Ribble Valley Borough Council
By email

Your ref 3/2024/0037
Our ref DC/24/448v2
Date 04-OCT-24

Location: Land adjacent to 7 and 9 Windy Street, PR3 2GD.

Proposal: Proposed drilling of two boreholes for ground source heating purposes and associated underground pipe work.

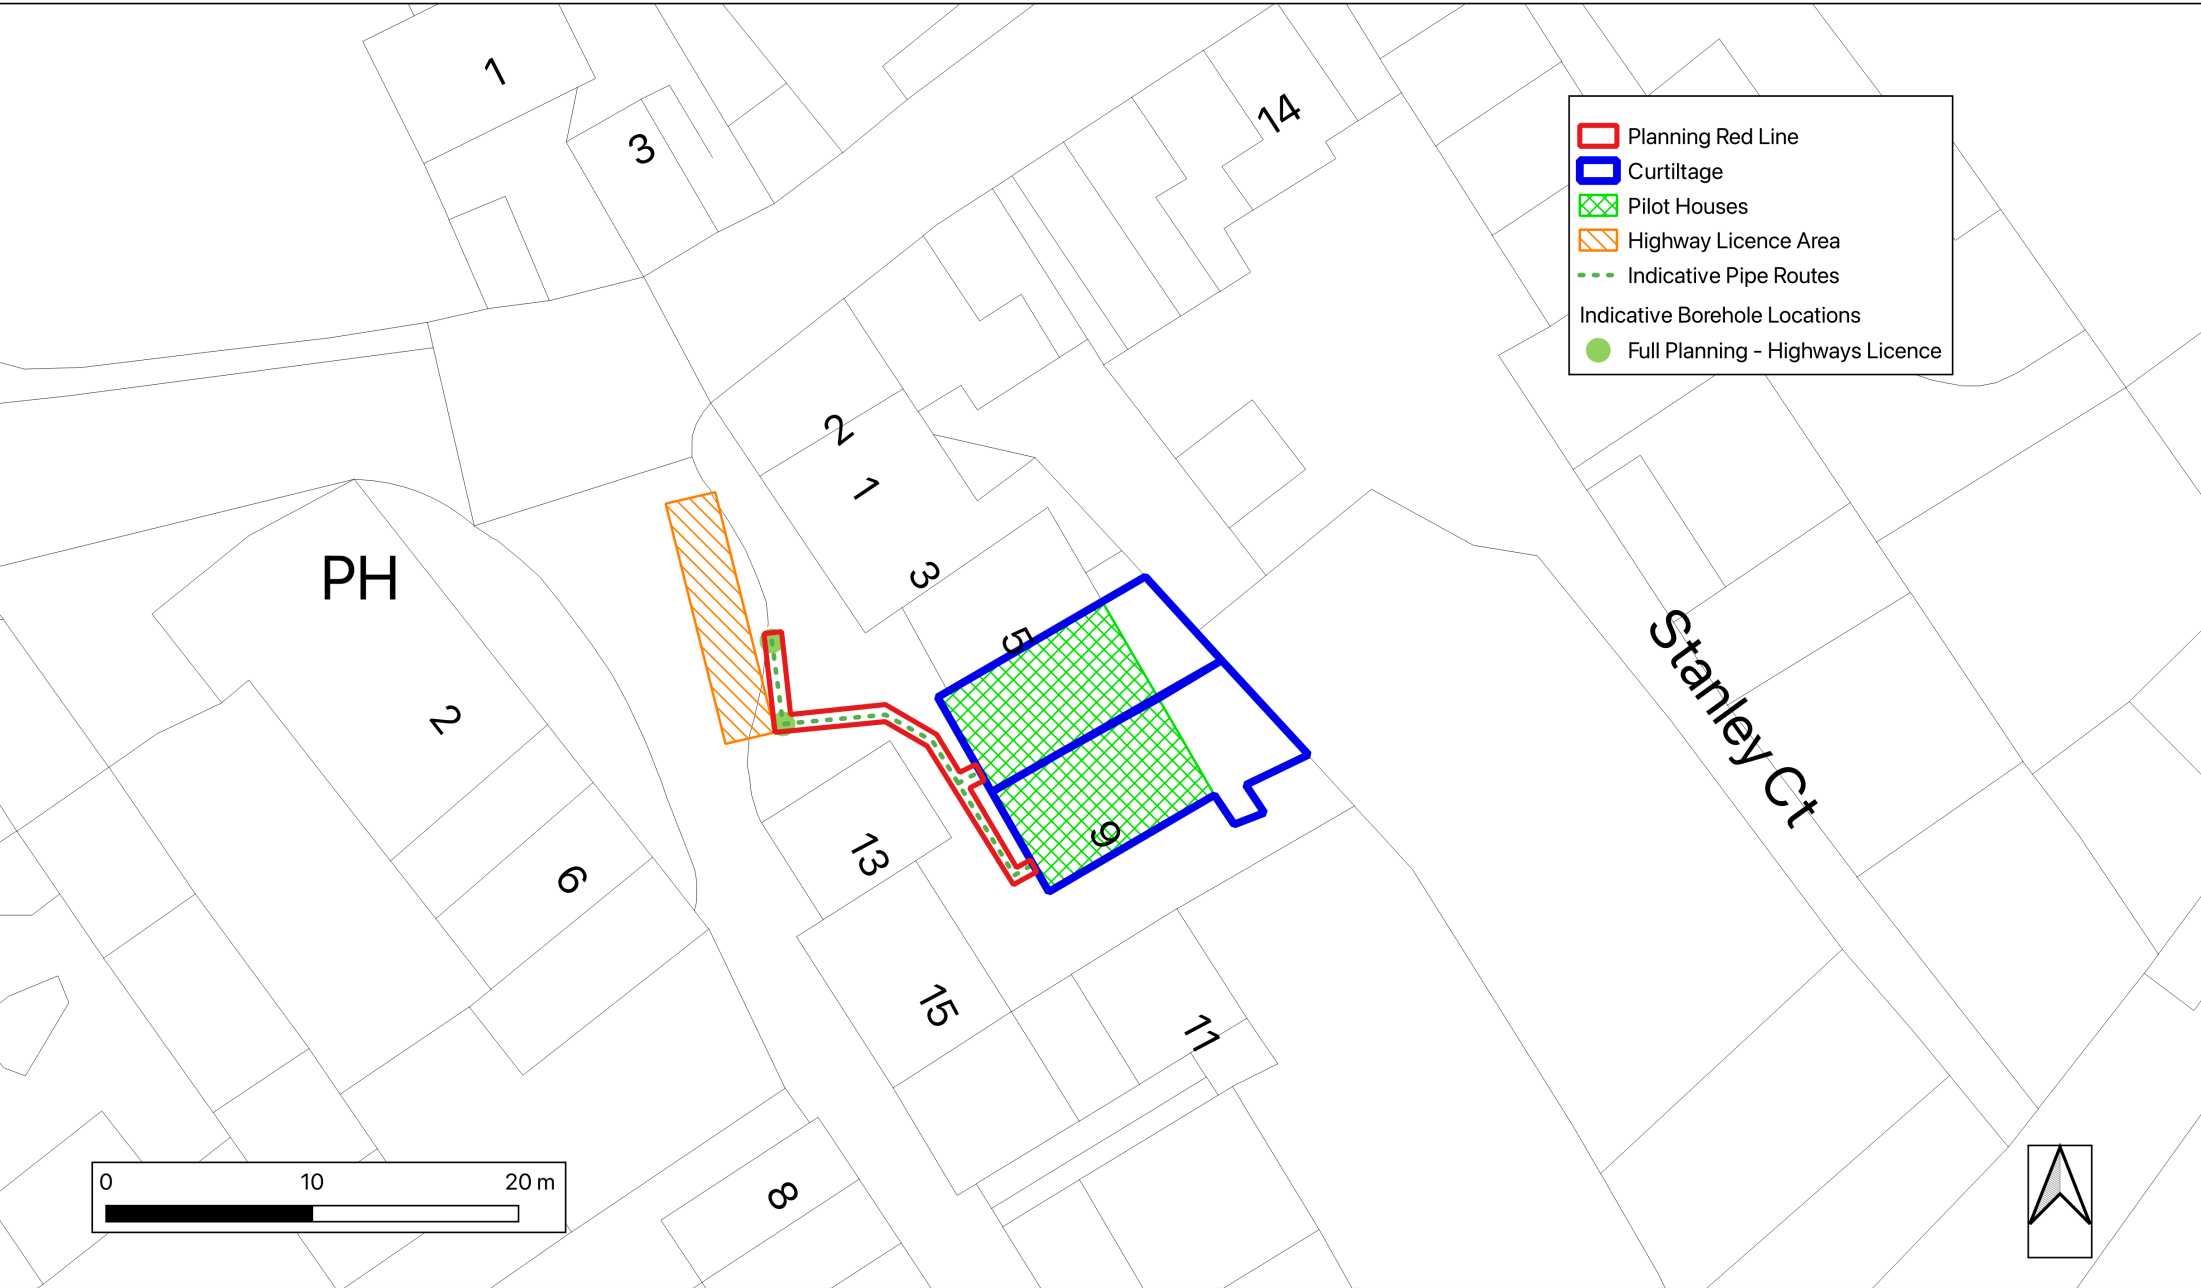
A public sewer crosses the site and we will not permit building over it. We require an access strip for maintenance or replacement and this access must not be compromised in any way.

The bore holes and ground source heat pipes shall be carried out in accordance with principles set out in the submitted Chipping Community Energy Network Design Drawing 22_011-CCE-SP_02/03, Rev 1 - and 22_011 - Chipping, Rev 1 which was prepared by Prospus Group LTD. For the avoidance of doubt pipework must be installed to a minimum of 0.6m vertical clearance and 0.7m horizontal clearance from the public foul sewer network.
